Application No: FP/224/20/HH
Site Address: 57 Minton Road Felpham PO22 7JX
Description of works: Two storey side and rear extensions to existing dwelling & replacement of existing front loggia.

Thank you for your internet representation made on 24th December 2020 which has been recorded as an objection with the comments as follows:

DRAWING
**ELEVATIONS
PROPOSED**
DRAWING No
323/05
REVISION
SCALE 1:100
DATE OCT 2020
DRAWN LA
CHECKED

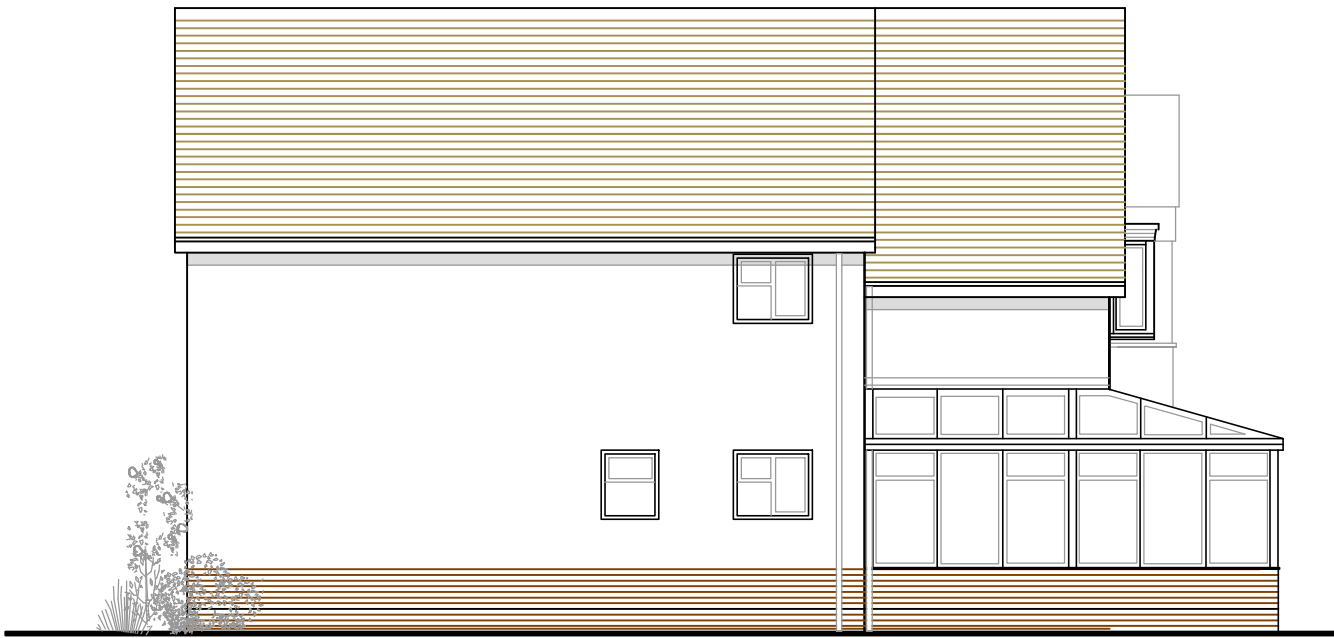
The extension is unneighbourly and overbearing, built right on the boundary, and will severely reduce the light to the adjacent property on the East side and significantly reduce the enjoyment of the rear garden. For all North facing gardens on the estate, light is a key consideration, and this proposal goes too far in reducing it.

The extension seems much too large to be built on the boundary, this is unreasonable, taking into account the height and length of the proposal and proximity to neighbours. This does not strike the right balance between allowing developments, and ensuring the impacts on others are not too great.
